From: Jonathan Best <Jonathan.Best@arun.gov.uk>
Sent: 06 May 2026 14:08
To: Planning.Responses <Planning.Responses@arun.gov.uk>
Cc: Simon Davis <Simon.Davis@arun.gov.uk>
Subject: AL/27/26/RES

Land adjacent to Woodgate Nurseries Lidsey Road Aldingbourne PO20 3SU.

I have reviewed this application with regards to ecology.

Brand: **BARRATT / DAVID WILSON HOMES**
Range: **2010 / 2016 & -5 / -7**
Title: **Hedgehog Highway Guidance**
Detail No: **DB-SD11-204**
Drawn: **GDT** Checked: **GDT** Scale: **NTS** Date: **Apr 23**

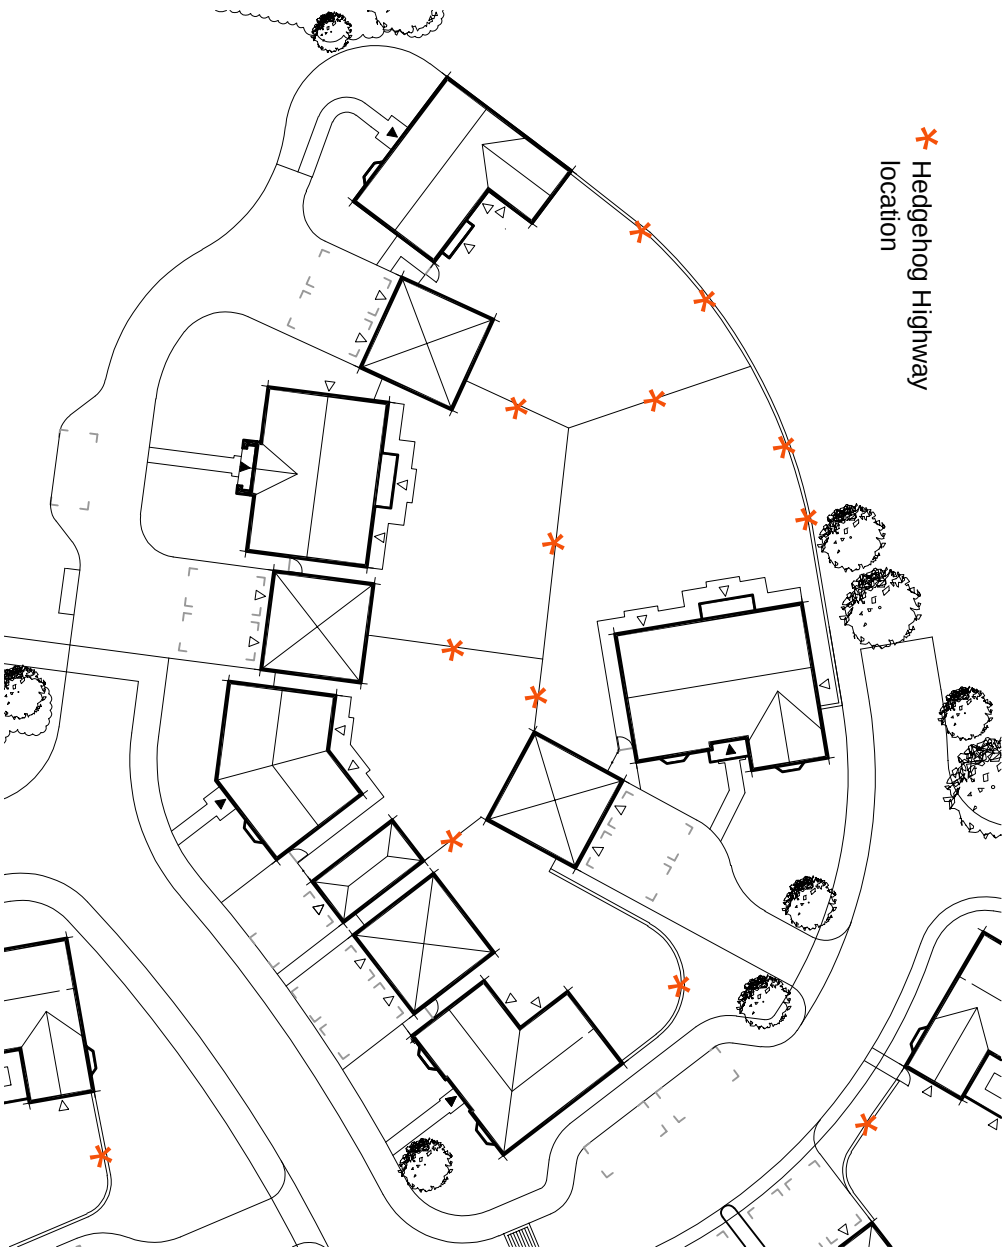
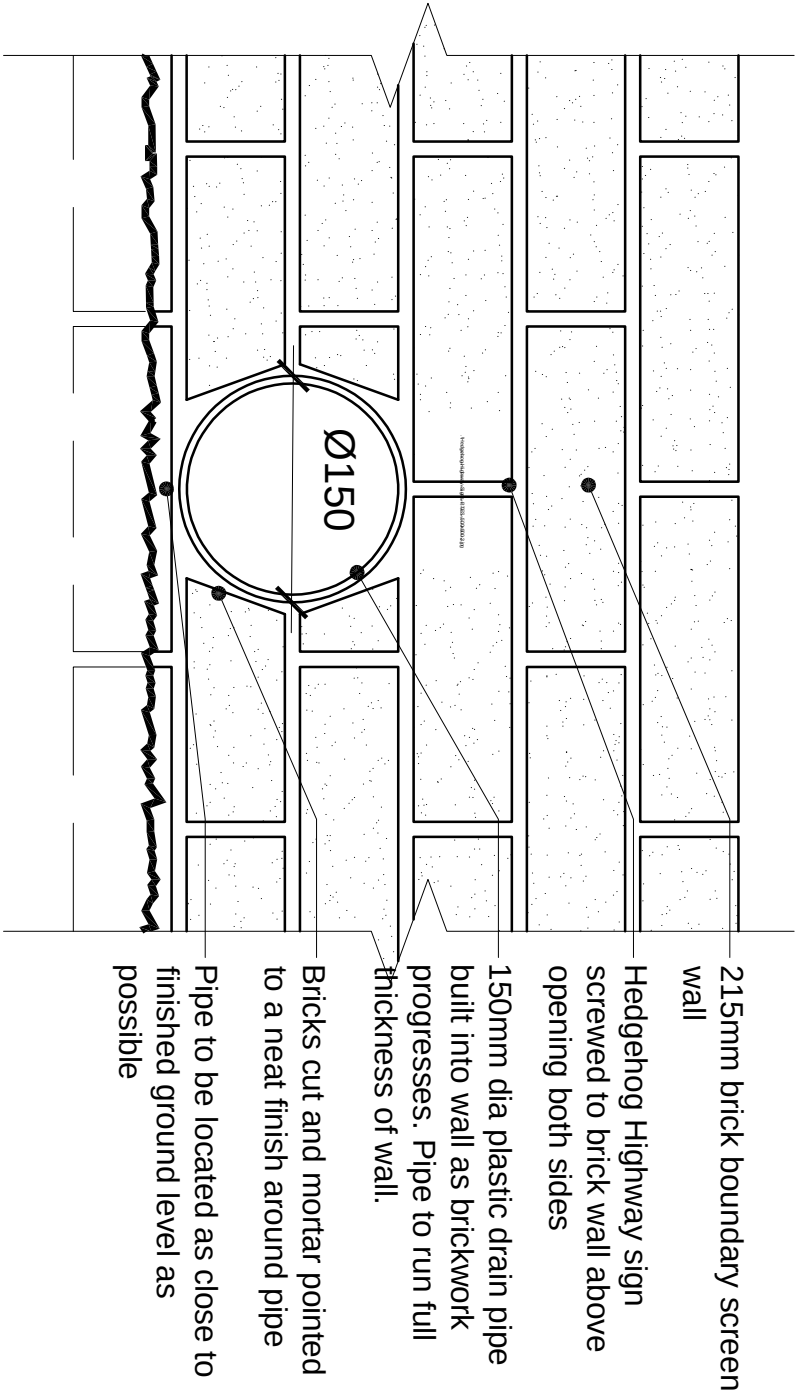
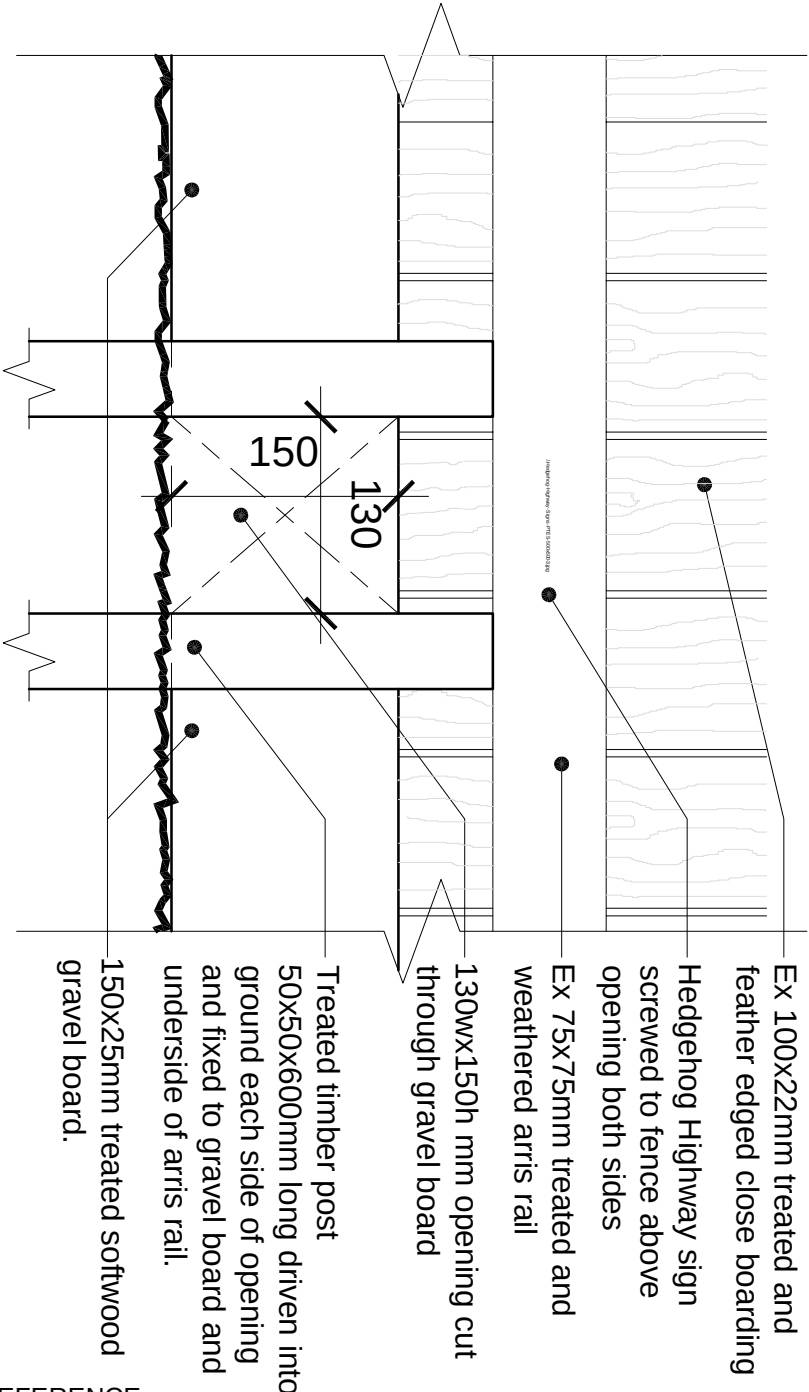
The plans show close boarded fences for the garden boundaries. The applicant should demonstrate that hedgehog gaps will be installed for each of the fences.
